From: Lorraine Davis
Sent: 24 October 2022 08:39
To: David Elmore
Subject: RE: Re: Comments on planning application. Former Beales Hotel, Hatfield. 6/2022/1355/MAJ

From: David Elmore <d.elmore@welhat.gov.uk>
Sent: 19 October 2022 10:58
To: Lorraine Davis <L.Davis@welhat.gov.uk>
Subject: RE: Re: Comments on planning application. Former Beales Hotel, Hatfield. 6/2022/1355/MAJ

From: David Elmore <d.elmore@welhat.gov.uk>
Sent: 30 September 2022 13:56
To: Lorraine Davis <L.Davis@welhat.gov.uk>
Subject: RE: Re: Comments on planning application. Former Beales Hotel, Hatfield. 6/2022/1355/MAJ

**L00\_50 BINS\_CORE\_A**  
1 : 50

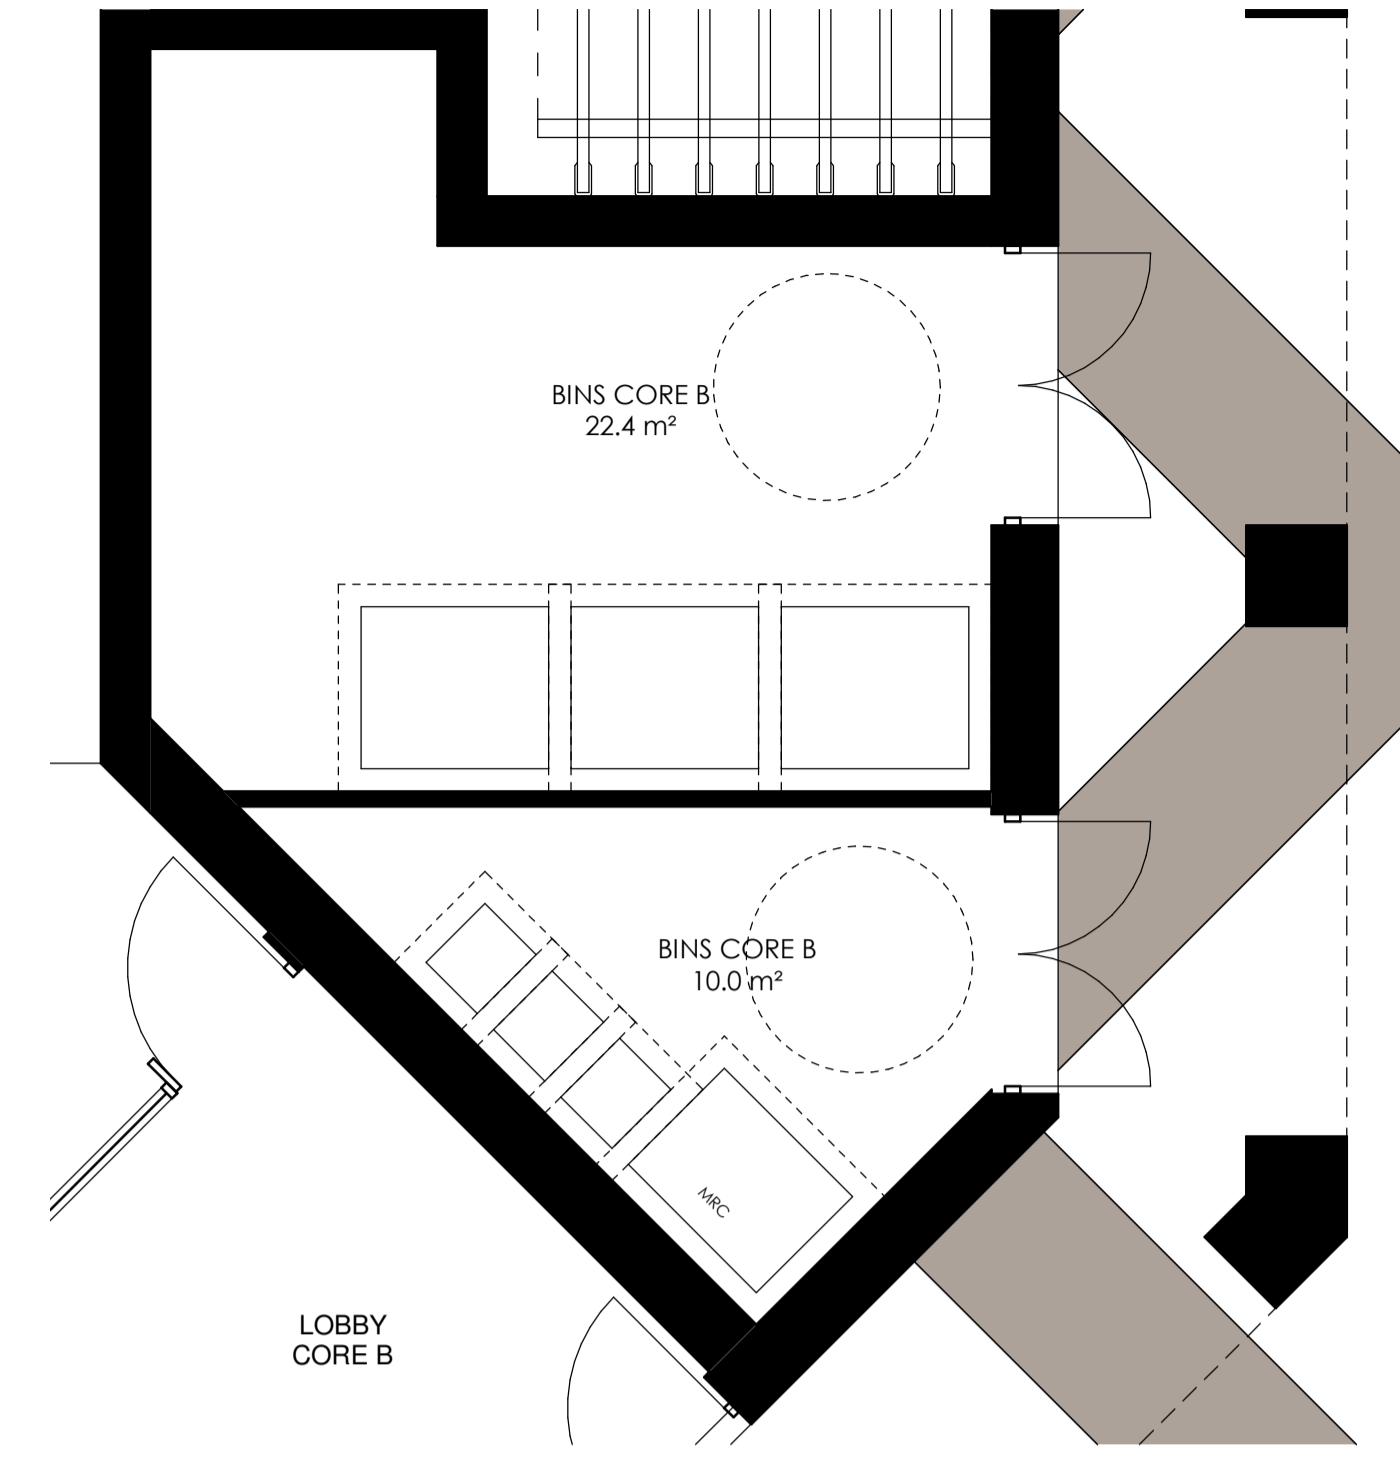
In terms of drag distances, you will see that these are not annotated on the plan. However, I have done the measurements using the scale bar and the drag distance from the bin store of Core A exceeds 15 metres.

The maximum number of receptacles for a Bin Store is 8, most of these Bin Stores (with exception of Core A) exceed that number and will therefore have to be split into 2 stores per core.

**L00\_50 BINS\_CORE\_D**  
1 : 50

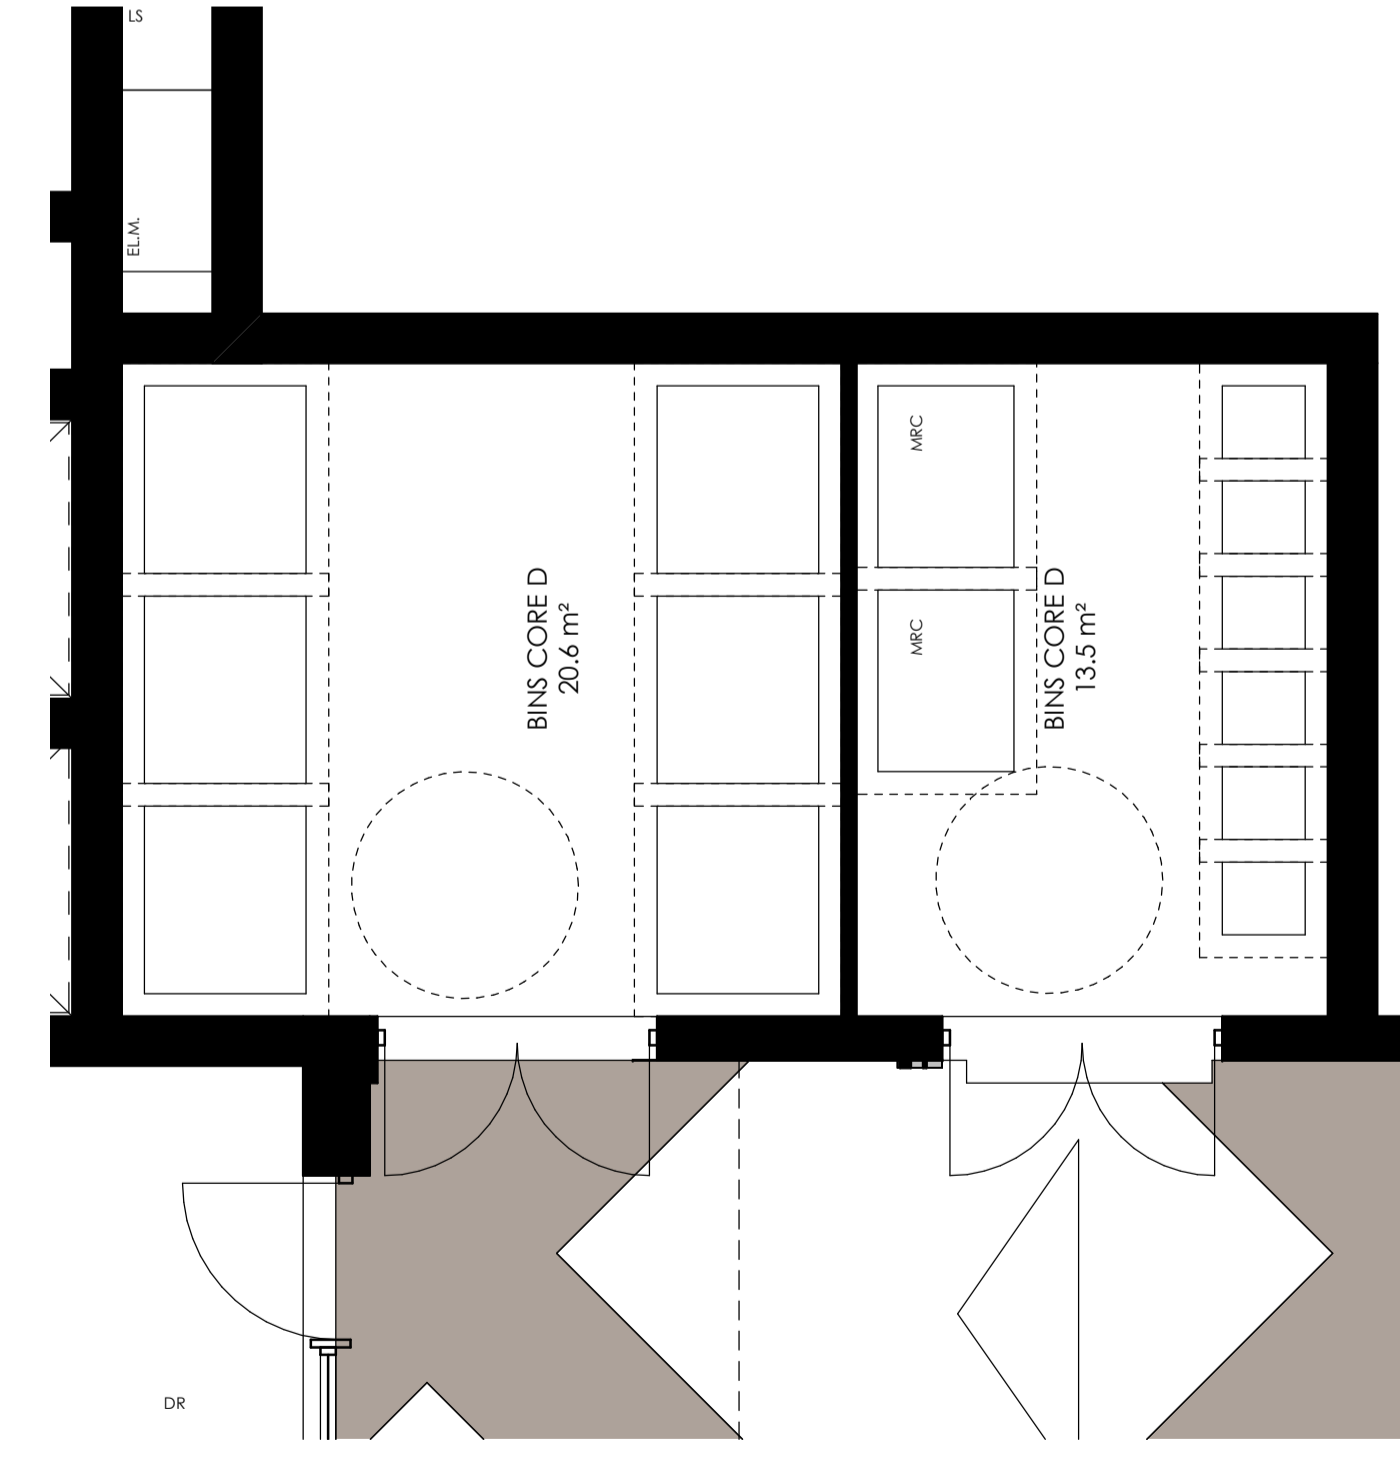
I am still not happy with the store areas containing the 1100's. The bins need to be able to be moved in and out one at a time for emptying, so they will enter store, collect a container take it to freighter, empty it and then return it to its original position before taking the next receptacles. some of these bins will impede the access and the crew would not be able to get to all bins without pulling out several bins in order to access others, also some bins are tucked half way behind another.

Still unsure of this block style paving, will the freighter be able to drive across this??, concern is the drag distance still....and that we require a smooth path from store to freighter to wheel the bins.

"Please see the attached further revised ground floor plan (PL02 rev. 02) showing that Core D bin stores have been regularised and enlarged to make it easier for operators to move the bins in and out. The overall bin and cycle provision remain the same. The block paving is concrete and suitable for vehicular access. I also refer you to Appendix 7 of the Transport Statement showing the refuse vehicle tracking in proximity to the Core D bin store (extract below). Please confirm this is acceptable and you agree the matter is closed".
